Corrections Narrative

DuBois Addition – 2955 74th Ave SE

4.7.23

WATER LINE PLAN
 SCALE: 1" = 20'
 2955 74th AVE SE
 NORTH MERCER ISLAND, WA 98040

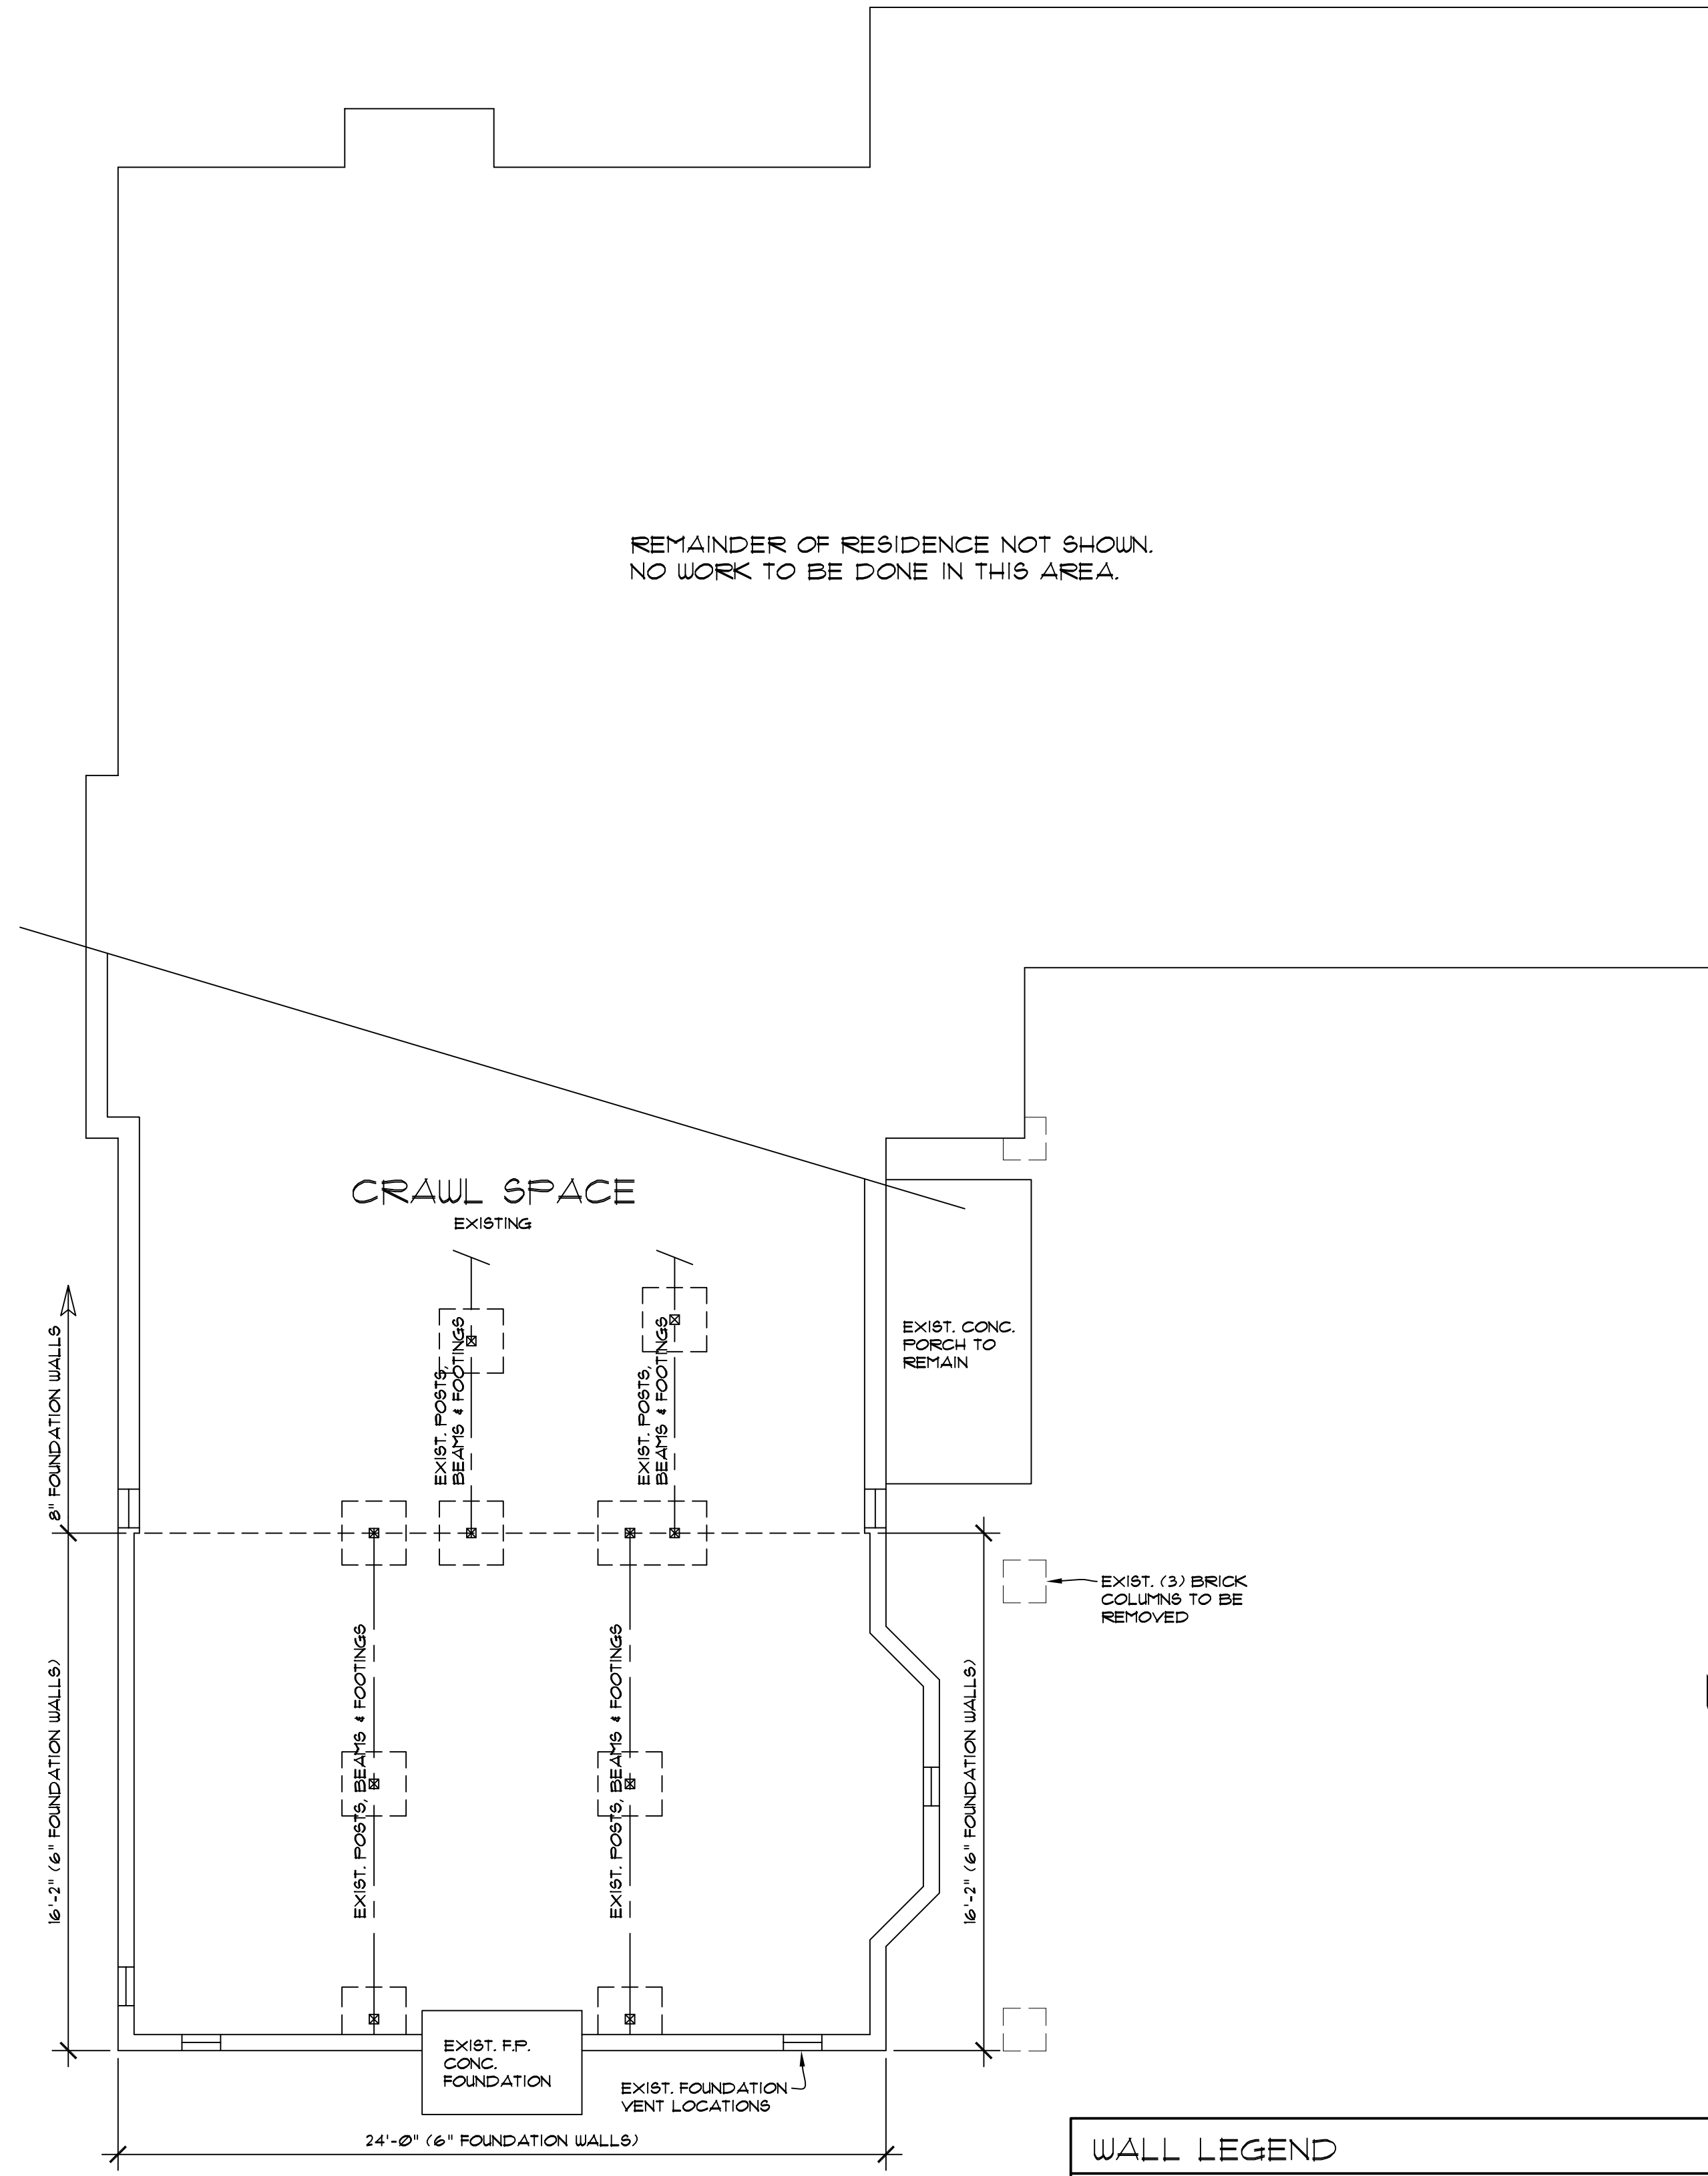
WATER SUPPLY LINE PATH – ENGINEERING (Kevin Nguyen)

Per Kevin Nguyen, the city plans to abandon the site's current water meter location off of 72nd Ave SE and install the new water meter off of 74th Ave SE. As such, we have updated the Water Line Plan accordingly. Responses to city comments have been published to the review file.

Updated sheets are limited to **sheet A0.5**. All other sheets were unchanged.
